Re: Planning Permission 30, Limmer Lane, Ref: FP/179/11/

Demolition of existing dwelling & outbuildings & erection of 6 no. apartments with associated parking & landscaping (re-submission following FP/182/10/)

30 Limmer Lane Bognor Regis

Drawing
Proposed Apartments
Site Layout & Block Plans

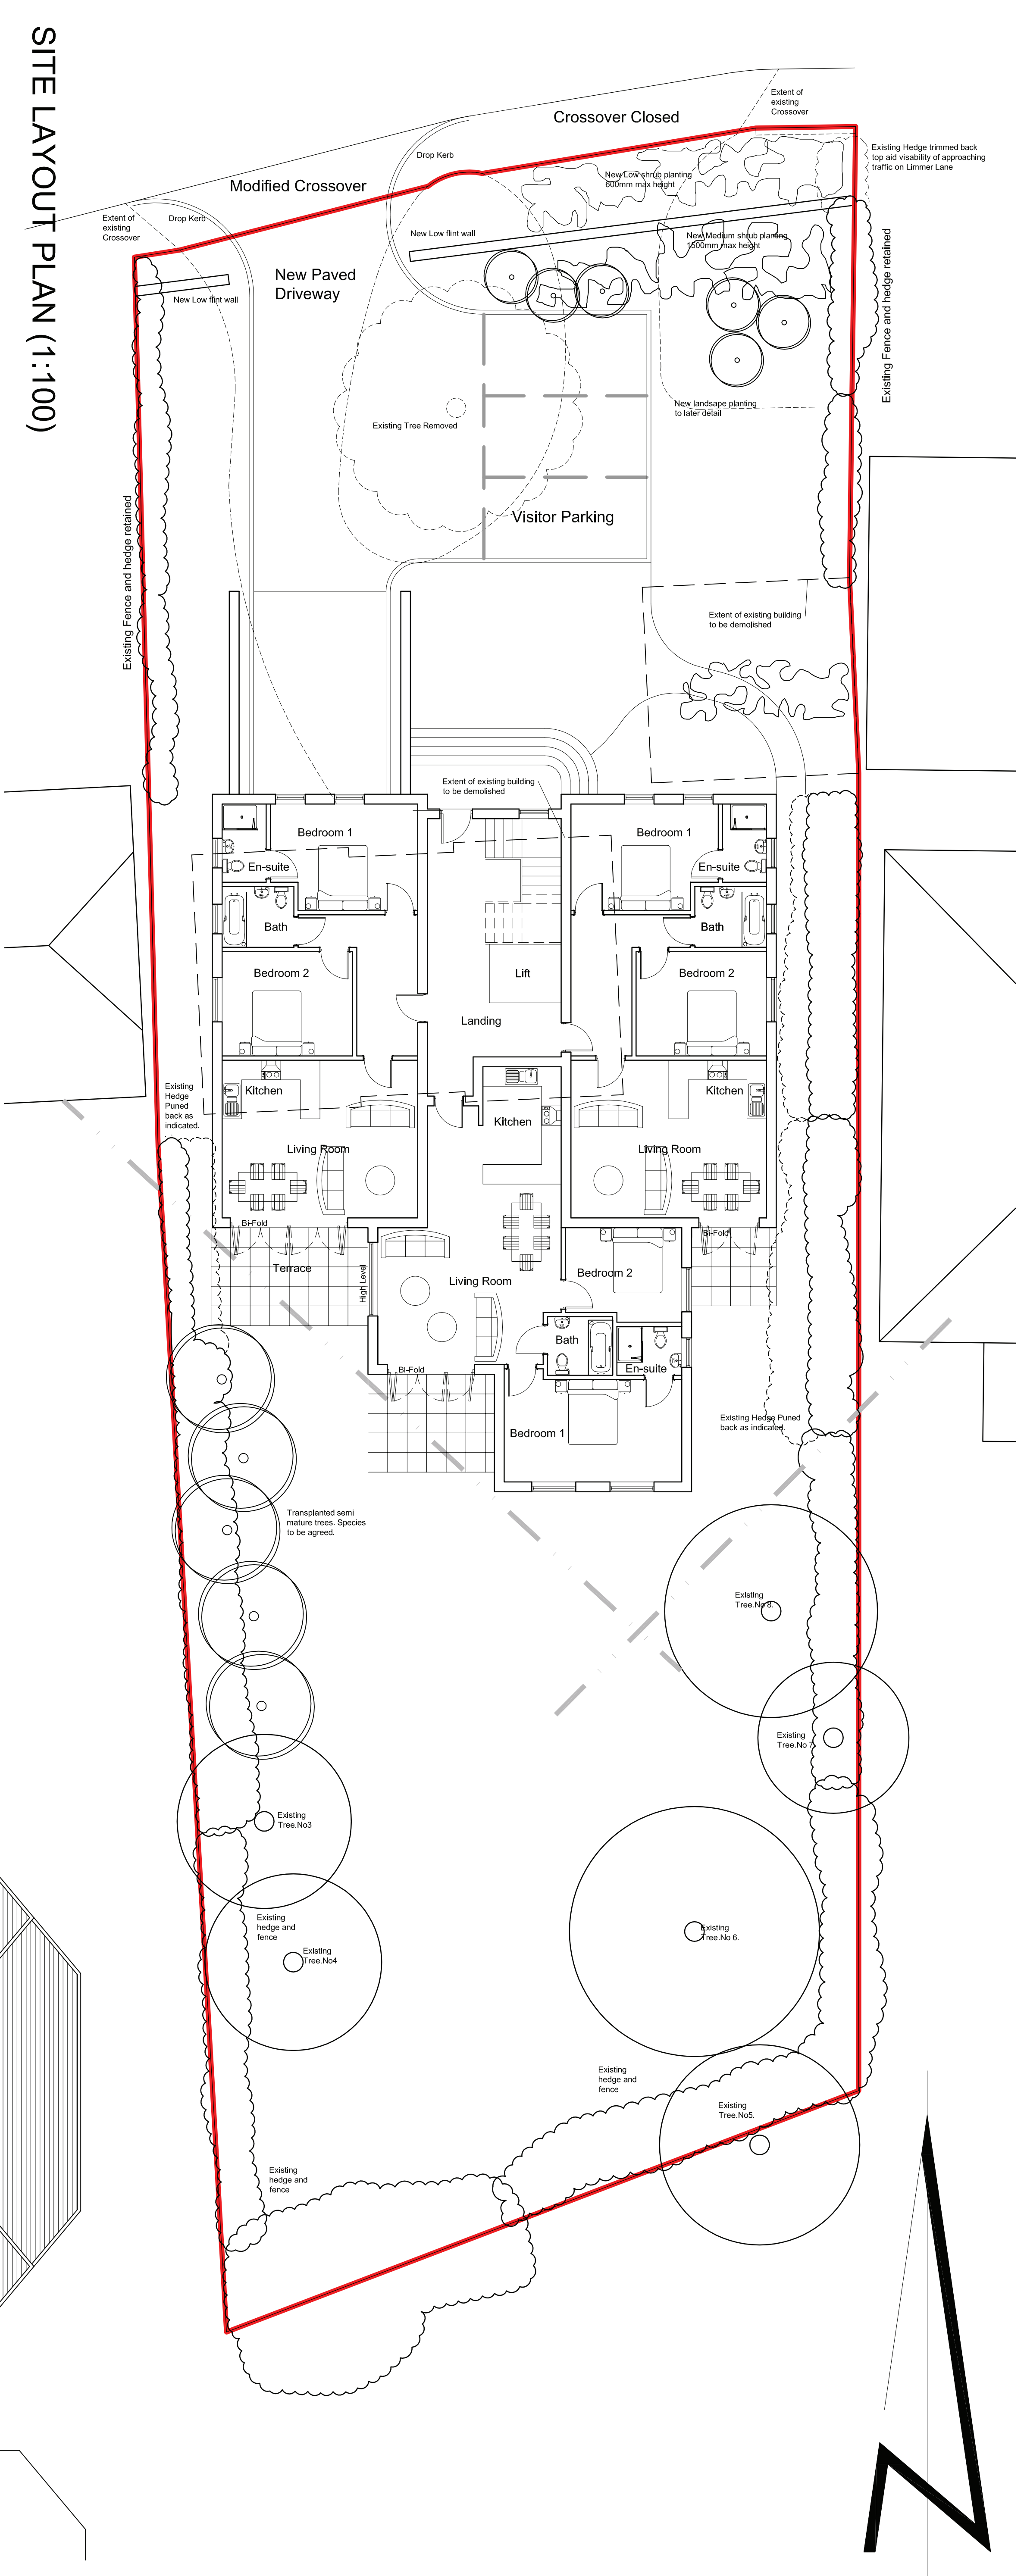
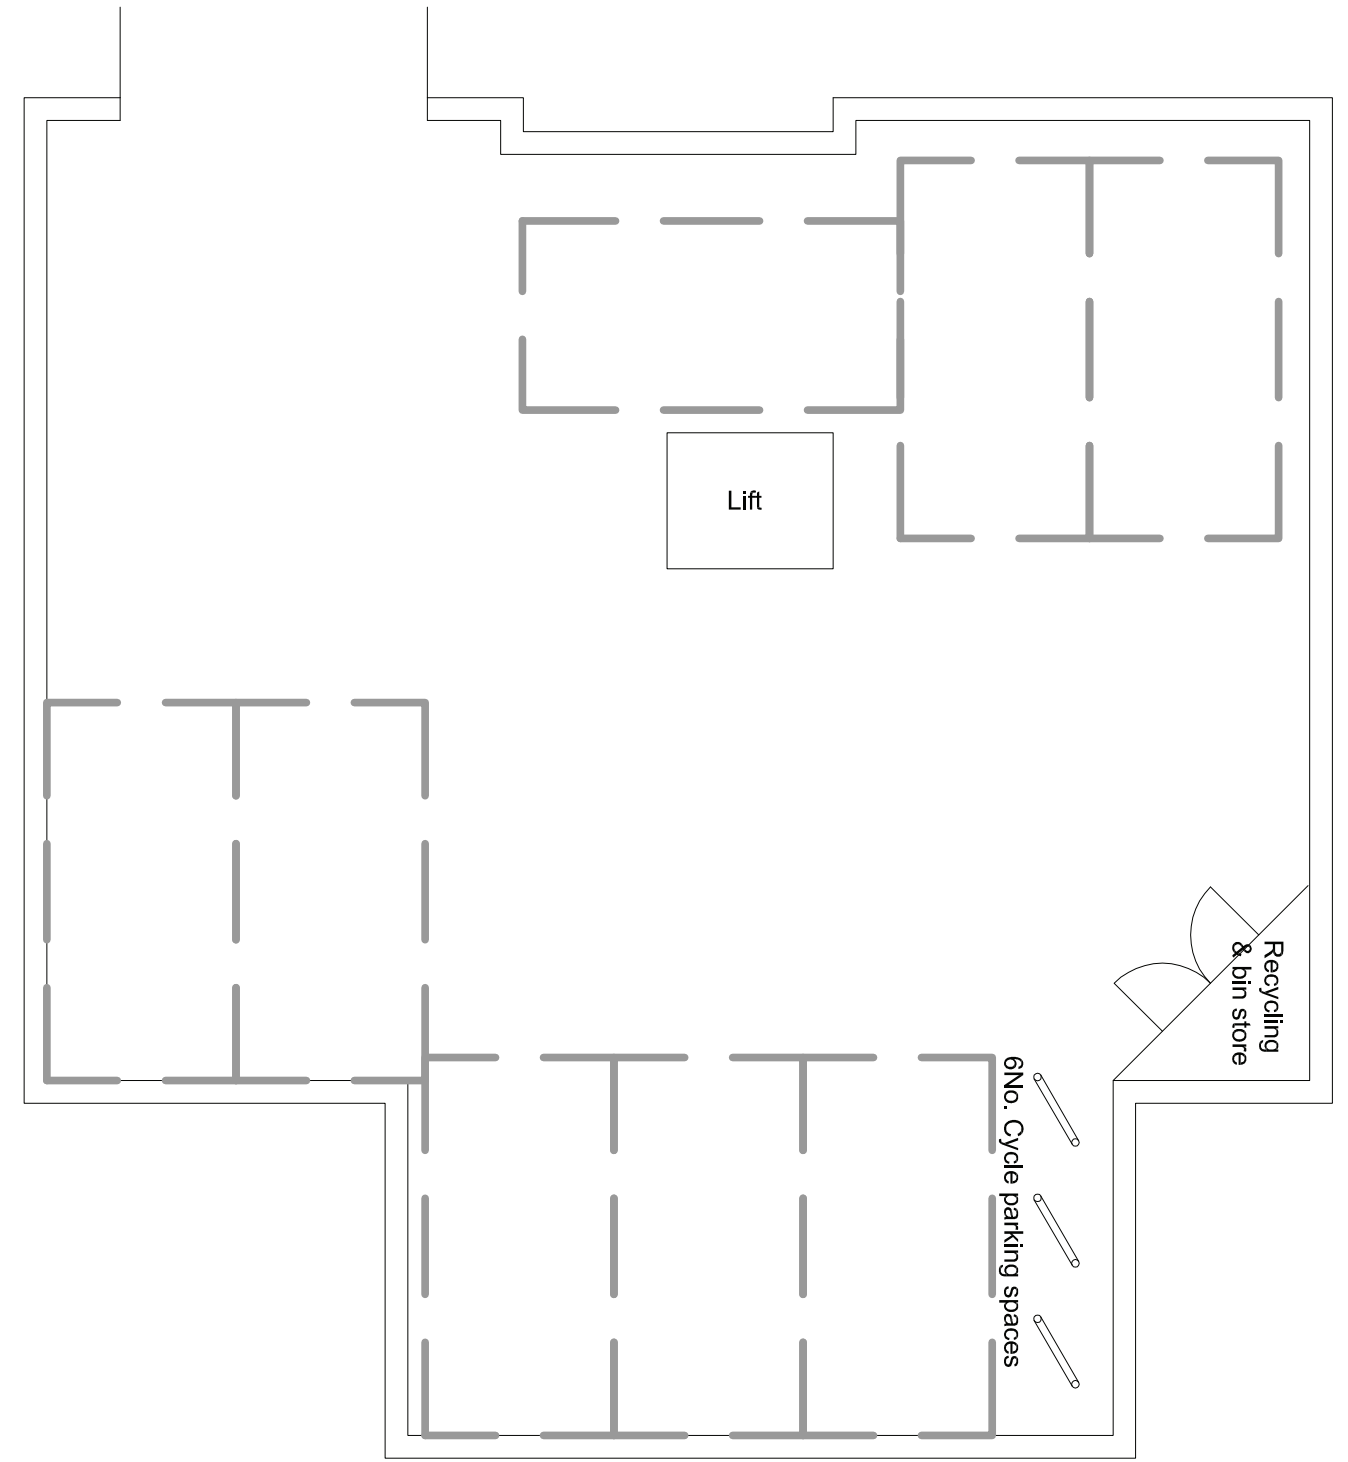
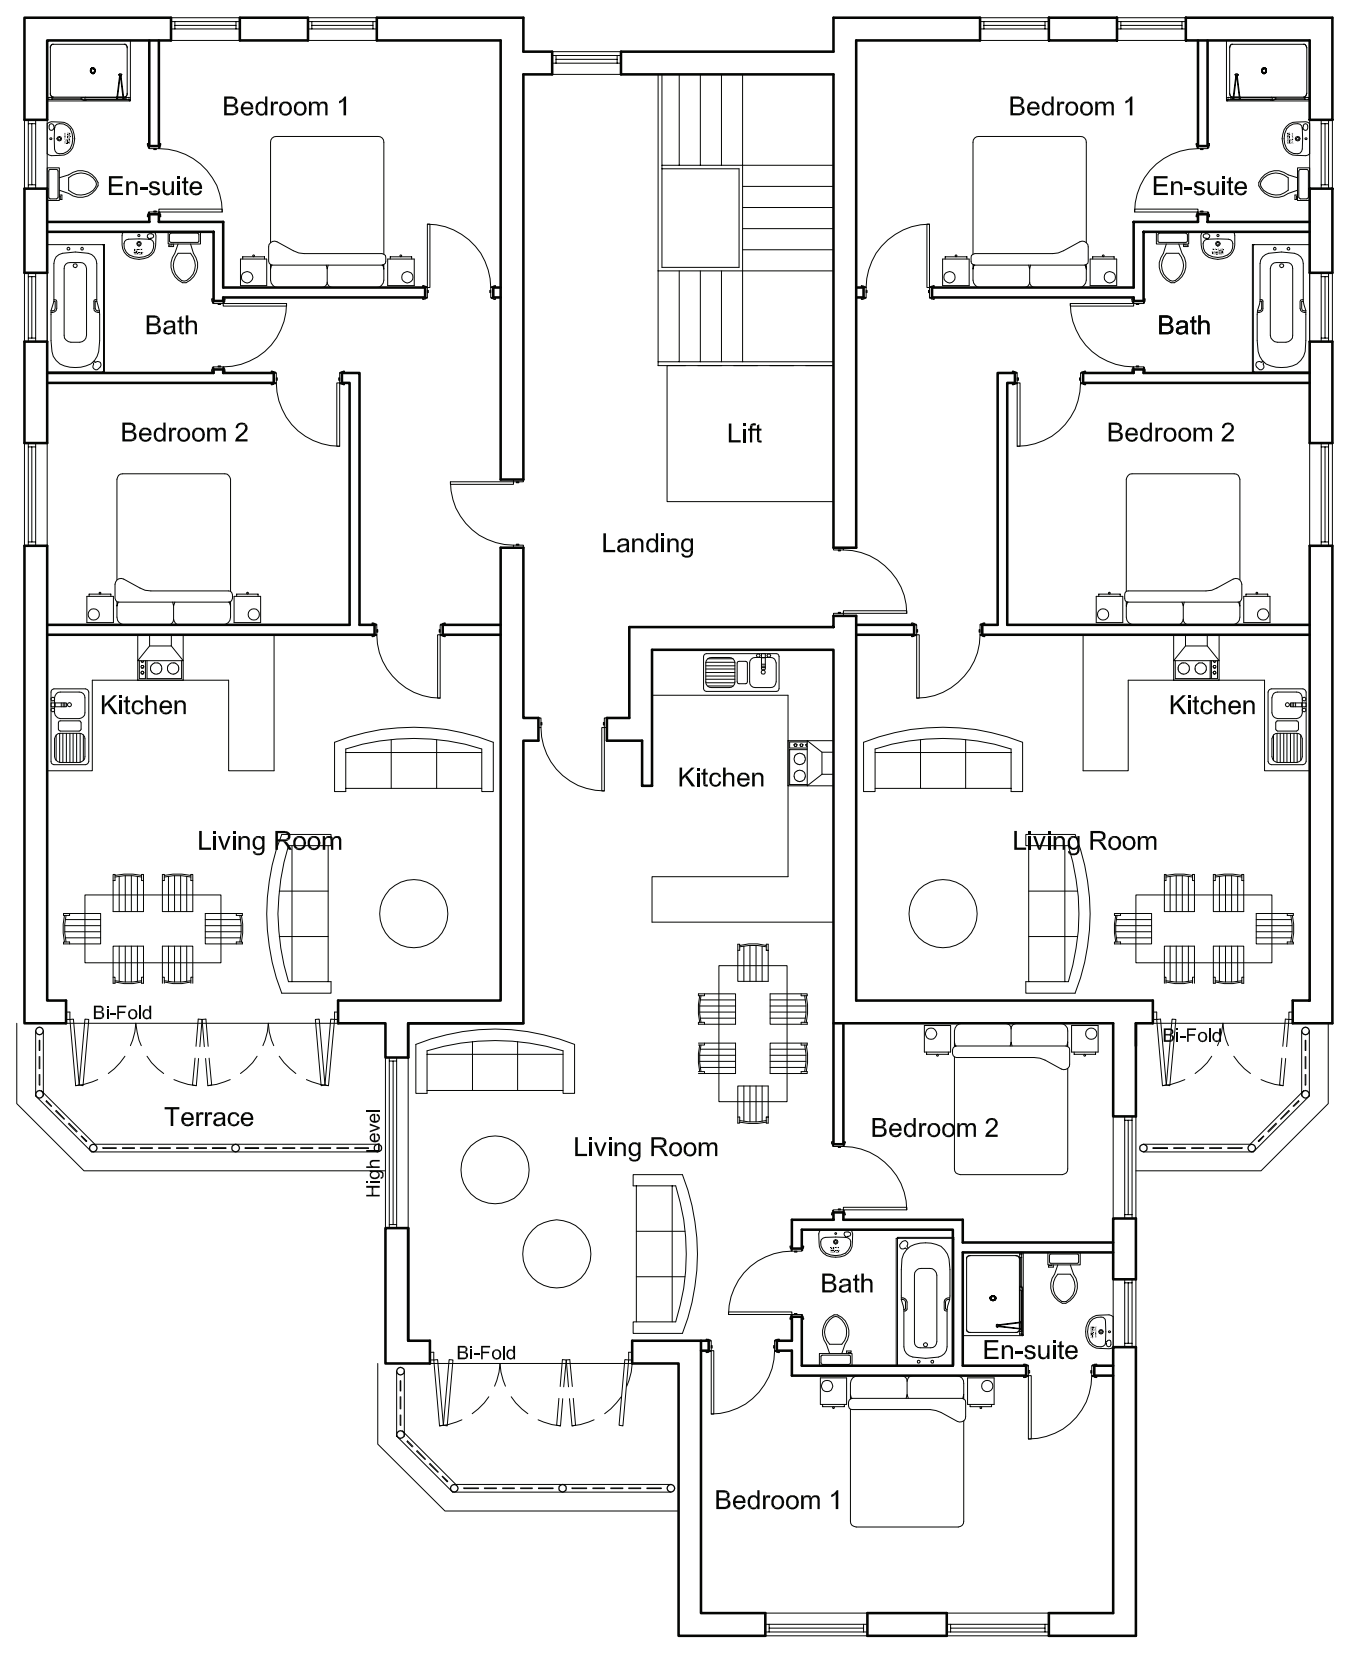
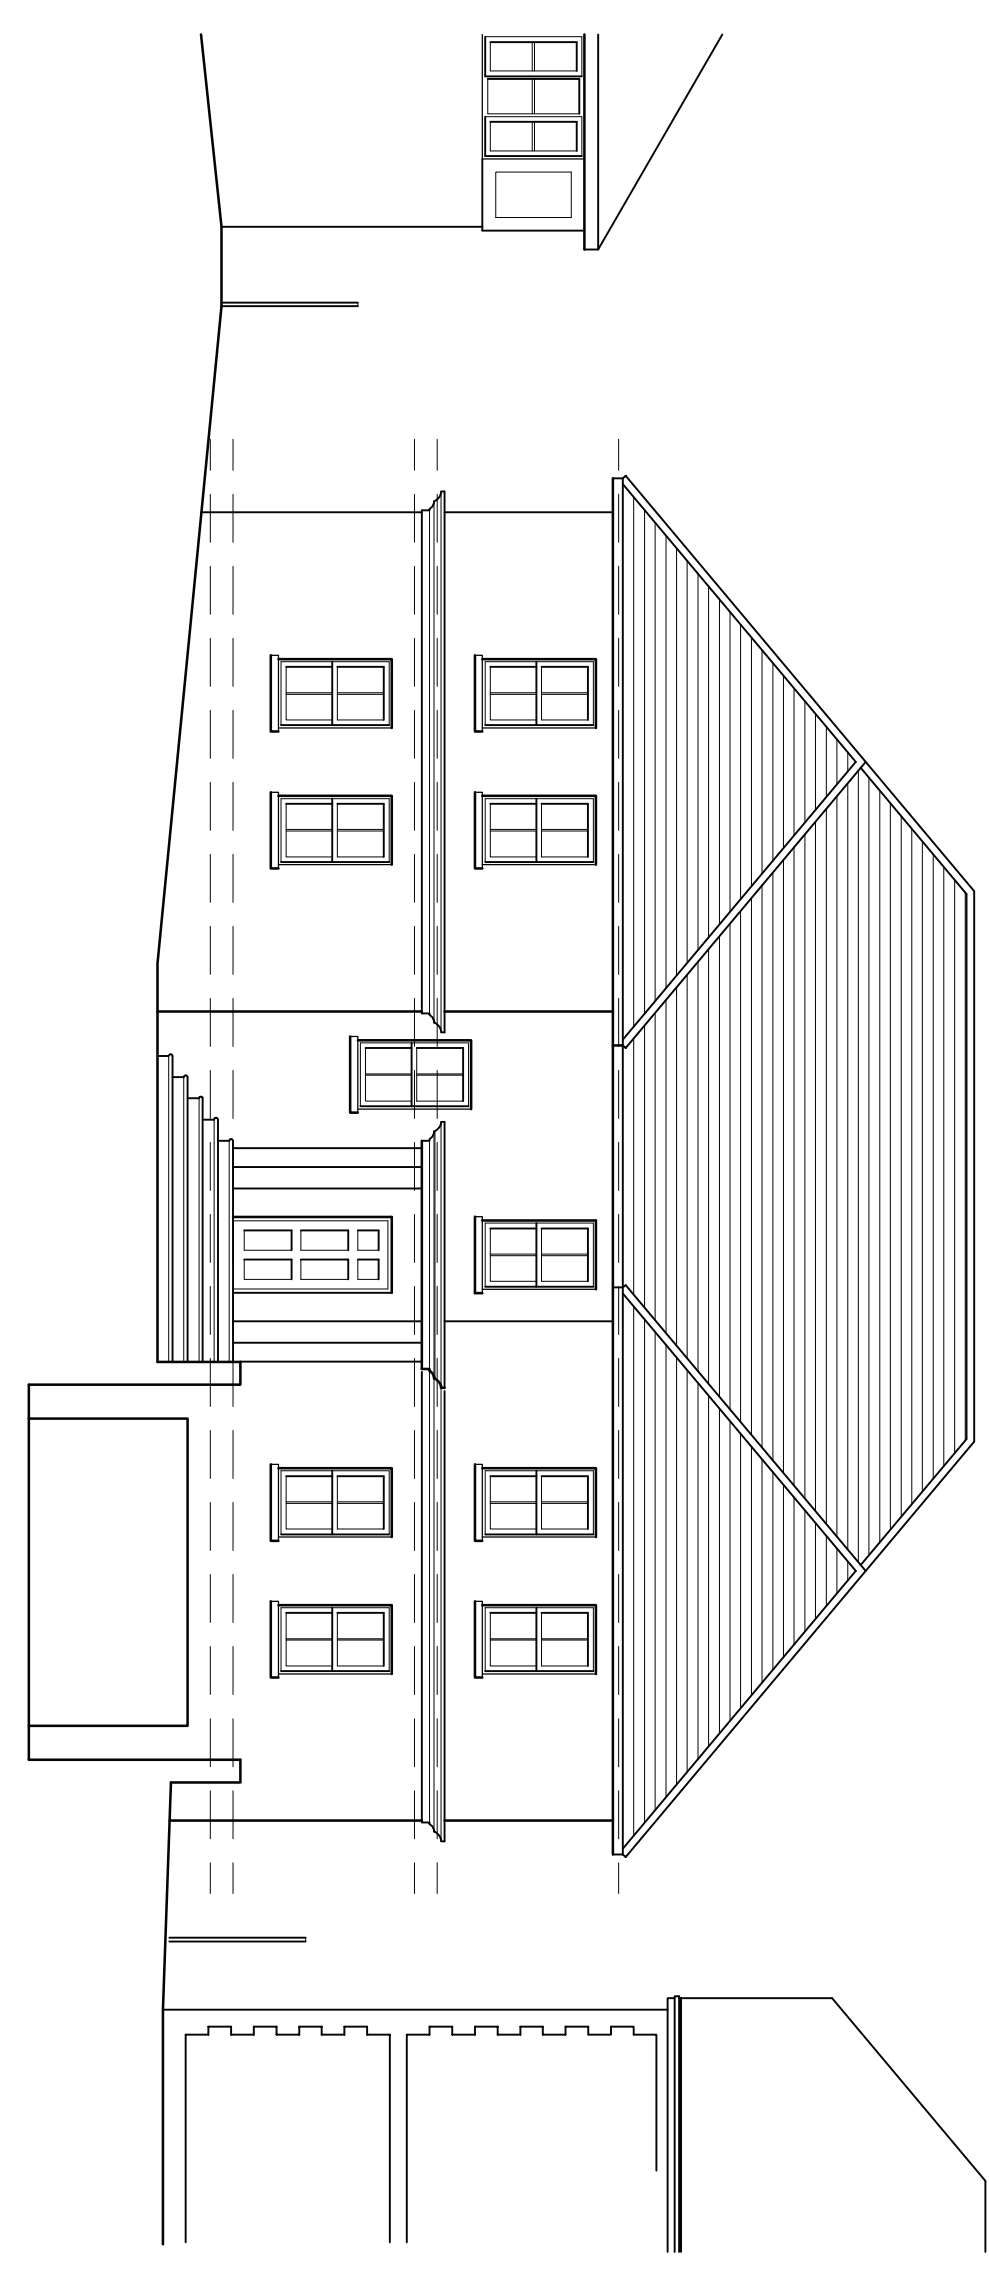
The intention to create dwellings for 12 people, with 11 parking places and access onto the road at the point of this bend creates significantly safety risks. Not only for people exiting the new properties but also for those traveling along the road exiting the T junction and children making their way to or from school. As a parent of 3 children going to local schools I am obviously very concerned about the risks this would pose.

As neighbors to the site of the new development this proposal would create a building over twice the current size and extend a substantial way down the side of our garden (more than the length of our house again). Our garden and house would be overseen, not just by one new dwelling but by 2 flats and terraces/balconies. The implications of this are that we lose most of our privacy.

The proposed new build runs very close to the edge of our external wall and then continues on further. The effect of this will be to significantly diminish the natural light into our sitting room, particularly as this is a south facing room.

- I. **There is "adequate turning space on site"** – Realistically there is inadequate space for 11 vehicles
- II. **There is "better use of land" while "respecting the private amenity space of adjacent properties and is sympathetic to their proportions"** – As a neighbor this development is too large, I believe it to be intrusive and significantly reduce my privacy. The existing building fits very well with the character of the road and area. To create a building of this size with all the associate activity would change this character and create a point of significant travel risk on the apex of this corner.

Underpinning this proposal is the development of basement car parking on this site. Whilst I do not understand the flooding issues fully the road outside this property has flooded on a number of occasions (approx 6) during the last 5 years since we have lived in the area. I would want to be assured that this development did not increase the risk of flooding to any neighboring property.
